From: Mark Warwick <Mark.Warwick@arun.gov.uk>
Sent: 23 May 2022 12:46
To: Kathryn Welch <Kathryn.Welch@arun.gov.uk>
Subject: FW: R/32/22/HH 30 The Parkway

I was wandering if you could provide a consultee comment for the above application (or just a quick email to indicate your thoughts) The proposed building works are to be situated partly within a RPA of a TPO'd beech tree on site.

Existing Wall	Proposed Wall

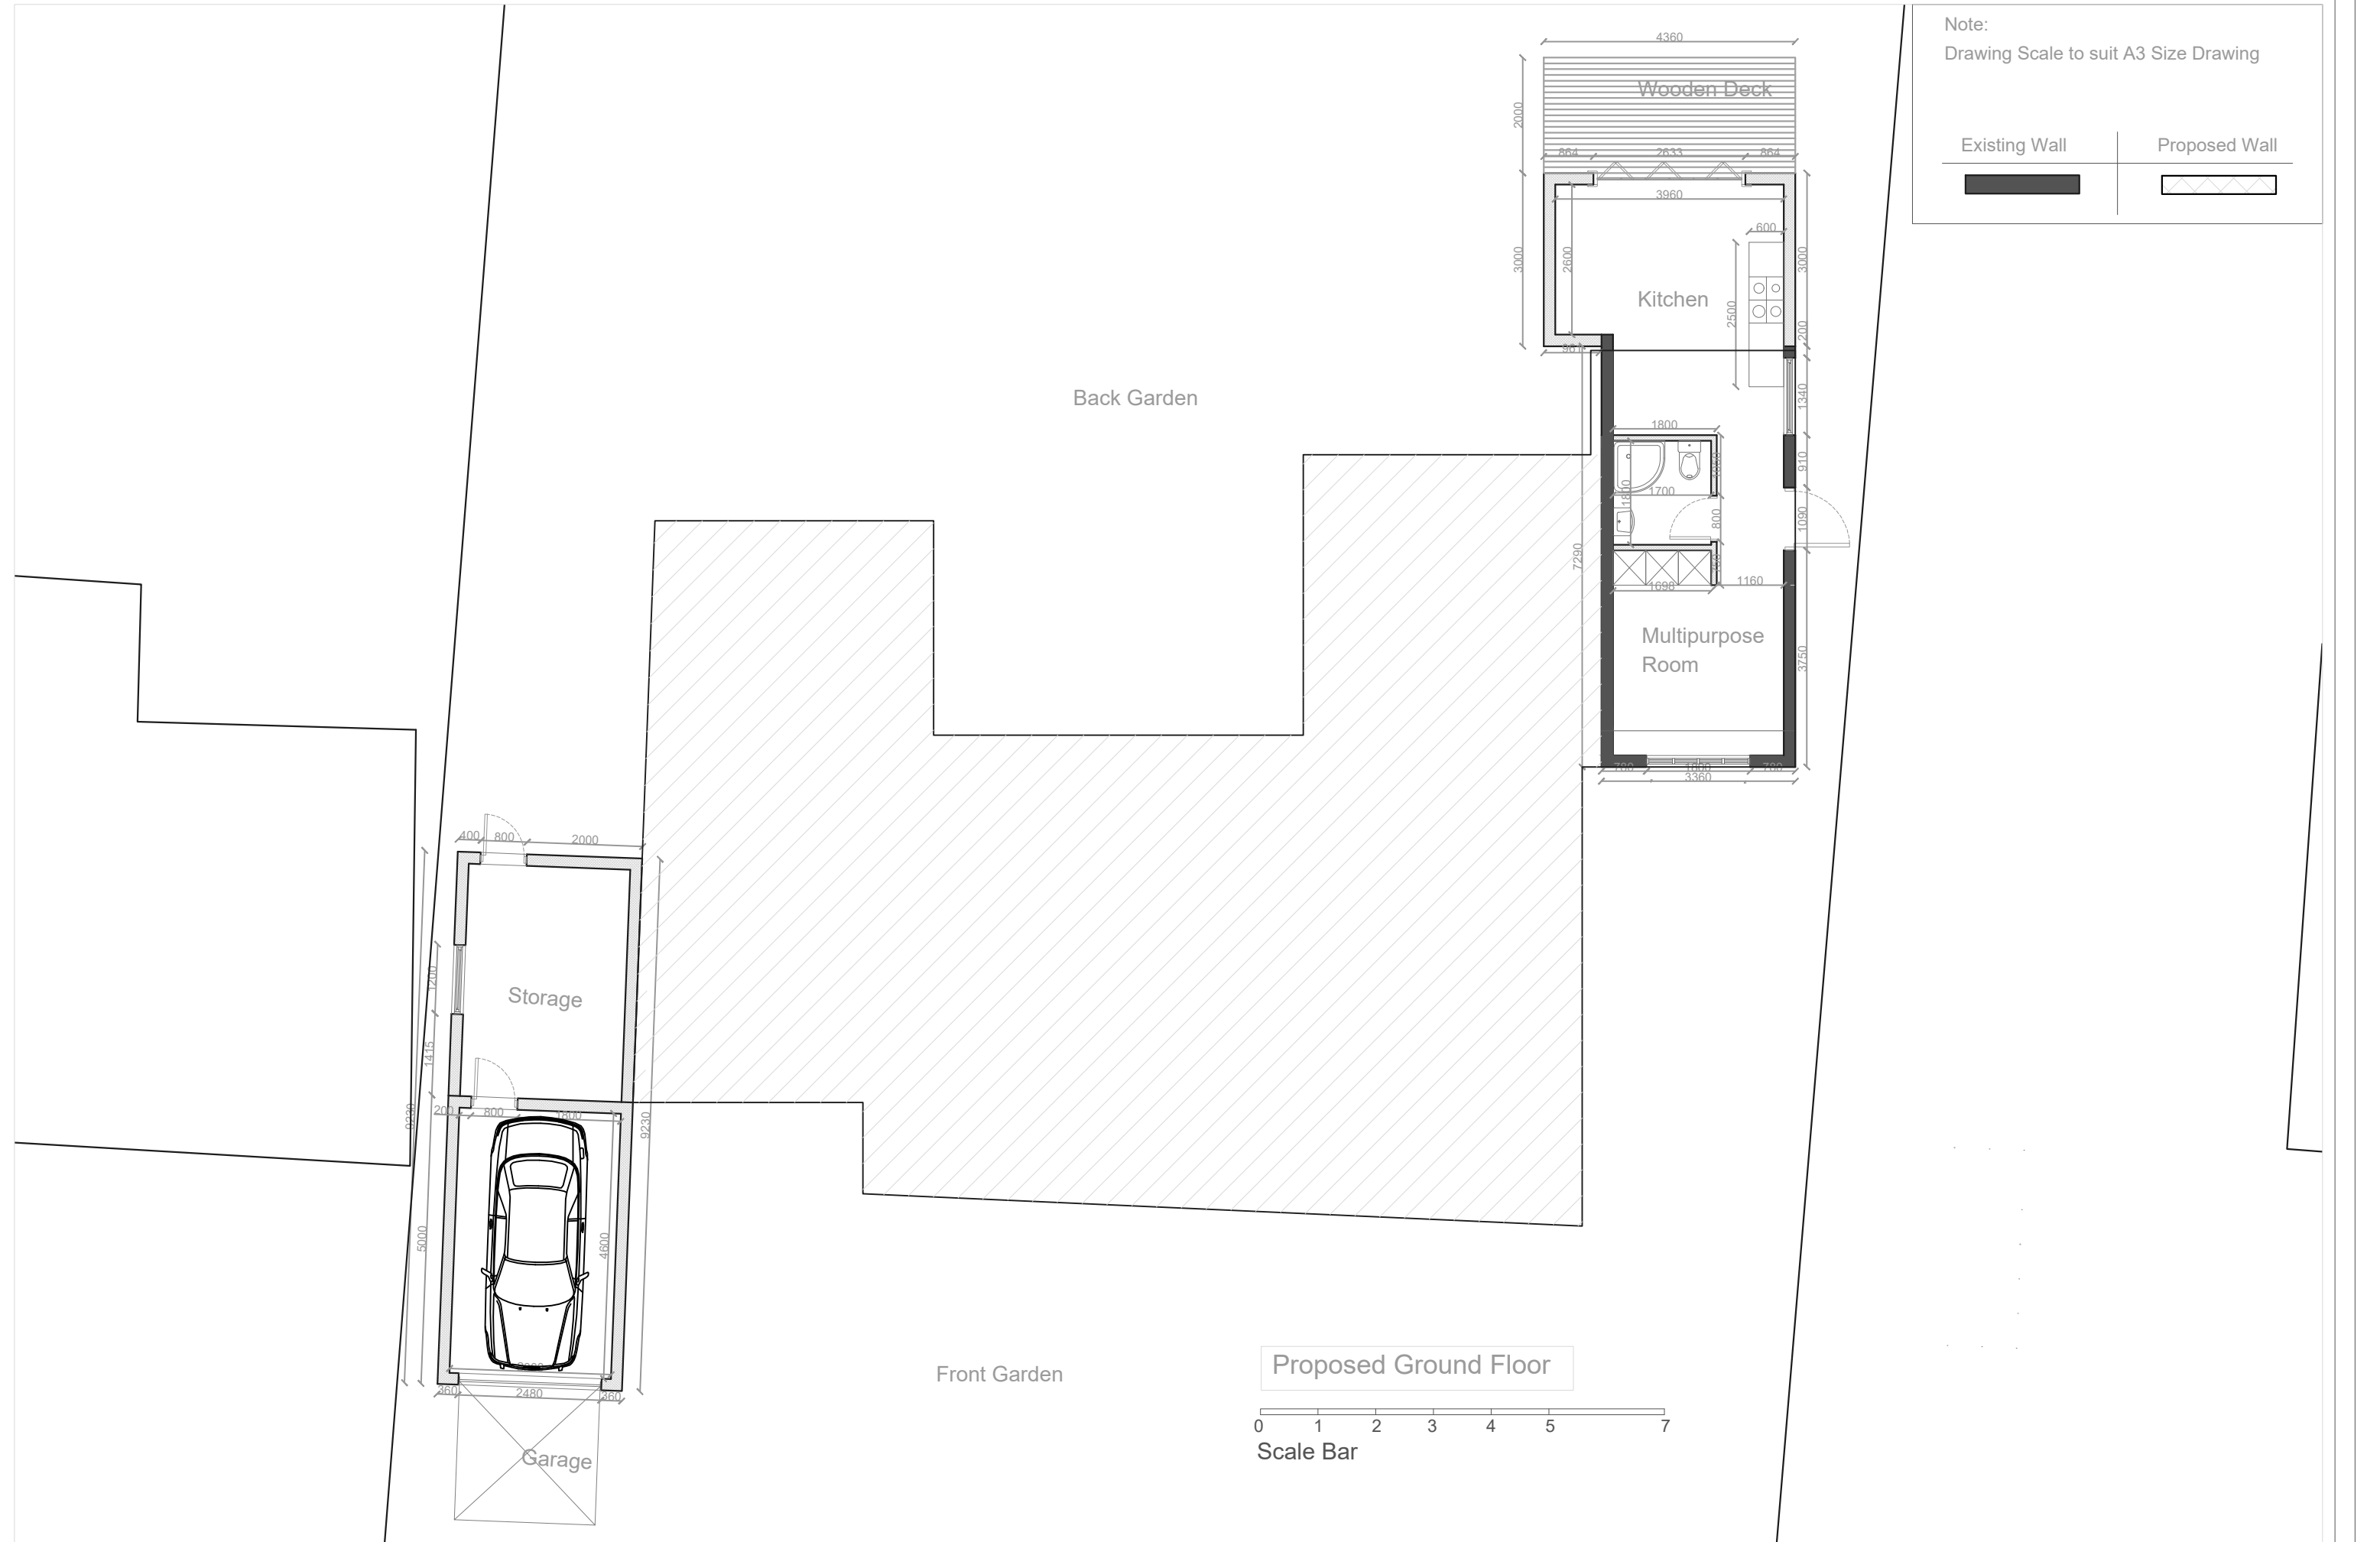
I did visit site 11 May and assess the beech tree from roadside. It is clear from their proposal (now withdrawn) that without early involvement from an arboricultural consultant there is a high risk of significant damage to the TPO tree. Despite recent hard pruning (approved) it remains a significant feature and offers some visual amenity. Some concern already for the deposition of building materials within the likely rooting zone of the beech tree, assumed to be associated with works along the front boundary.

The applicants will need to employ the services of an Arboricultural Consultant to carry out a tree survey exercise and then prepare an Arboricultural Impact Assessment (AIA) which must be inclusive of; a 'Tree Survey Schedule', a 'Root Protection Area (RPA) Schedule' and a 'Tree Constraints Plan' – with the trees accurately plotted on same.

If an RPA of any tree which is proposed for retention overlaps the development, then BS5837:2012 requires that the Detailed Planning Application is accompanied by an Arboricultural Method Statement (AMS) and most importantly a Tree Protection Plan – to both describe and illustrate the mitigation measures which are to be employed to ensure that the trees survive without detriment to their vigour and vitality and are given adequate protection both above and below ground.
